**Transport
for NSW**

**Mixed use development at Site 53, Sydney Olympic Park (SSD 7033)
Notice of Exhibition**

CD15/18831

2 FIGTREE DRIVE, SYDNEY OLYMPIC PARK
STAGE 2 : DEMOLITION
CONSTRUCTION TRAFFIC AND
PEDESTRIAN MANAGEMENT PLAN
10 JUNE '15
15S1505100-01

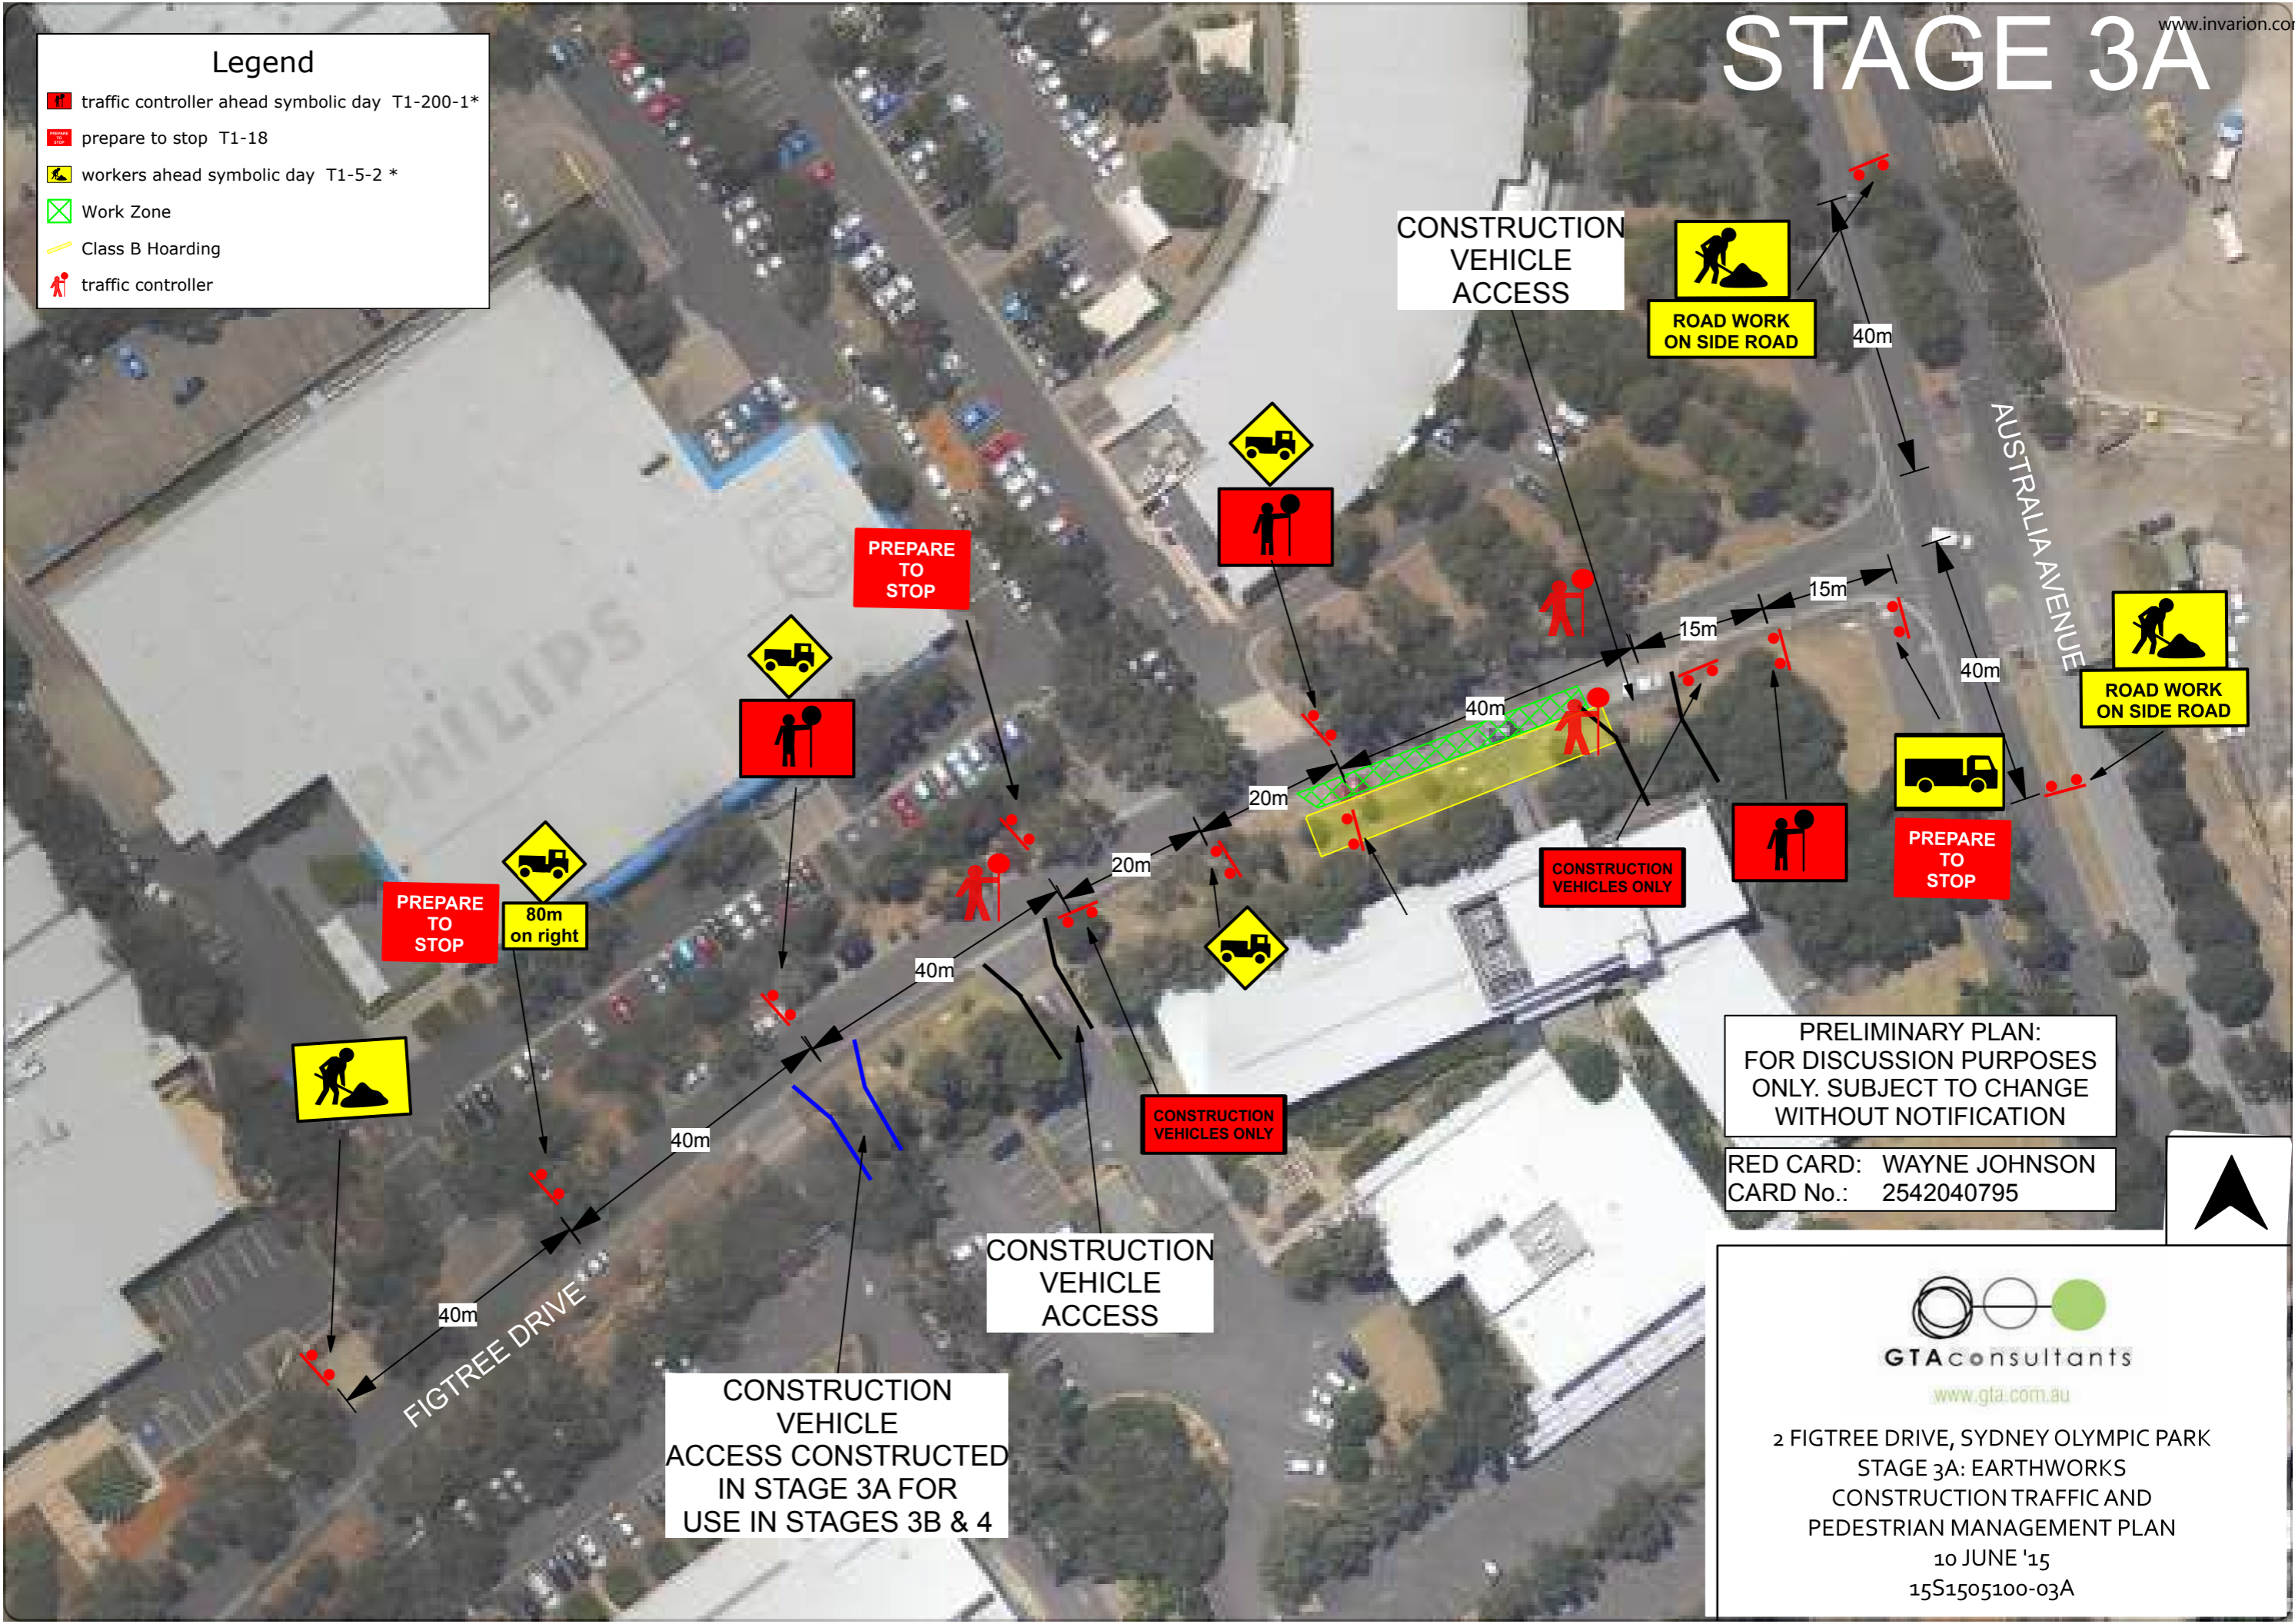
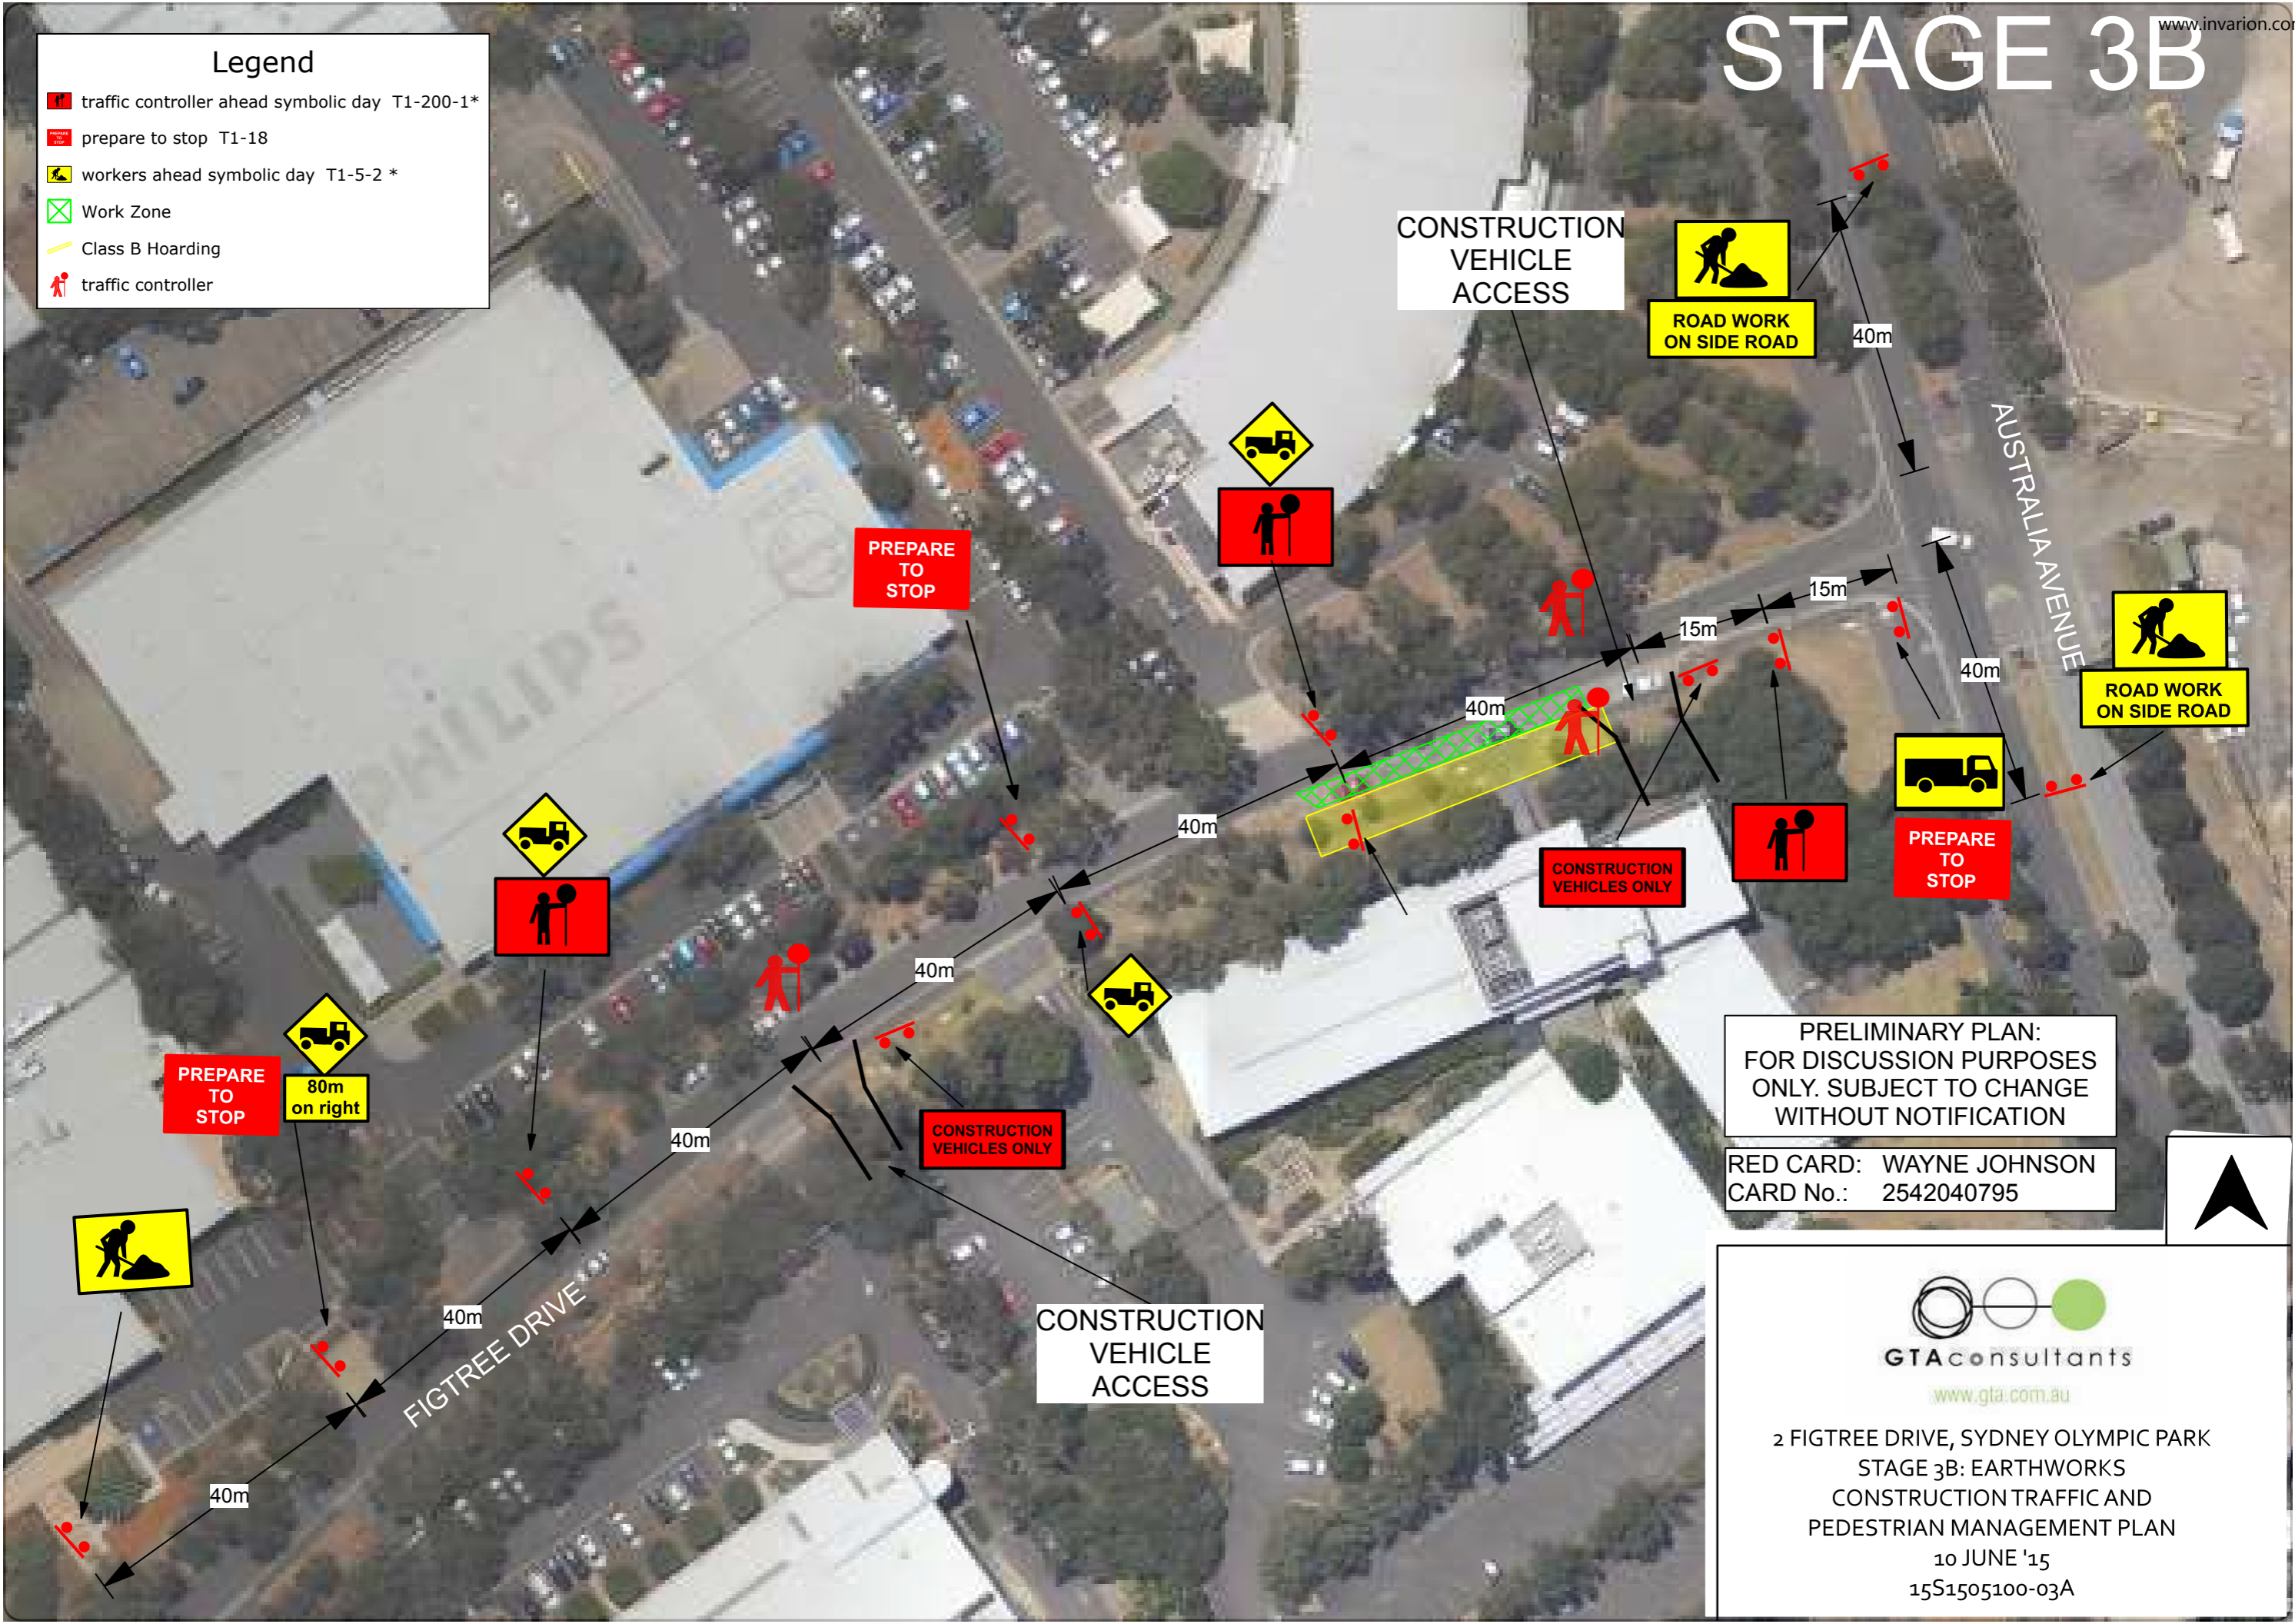
TfNSW requests that a Construction Traffic Management Plan (CTMP) be prepared in consultation with TfNSW prior to the commencement of construction. The CTMP needs to specify any potential impacts to general traffic, cyclists, pedestrians and bus services within the vicinity of the site from construction vehicles during the construction of the proposed works. Should any impacts be identified, the duration of the impacts and measures proposed to mitigate these should be clearly identified and included in the CTMP.
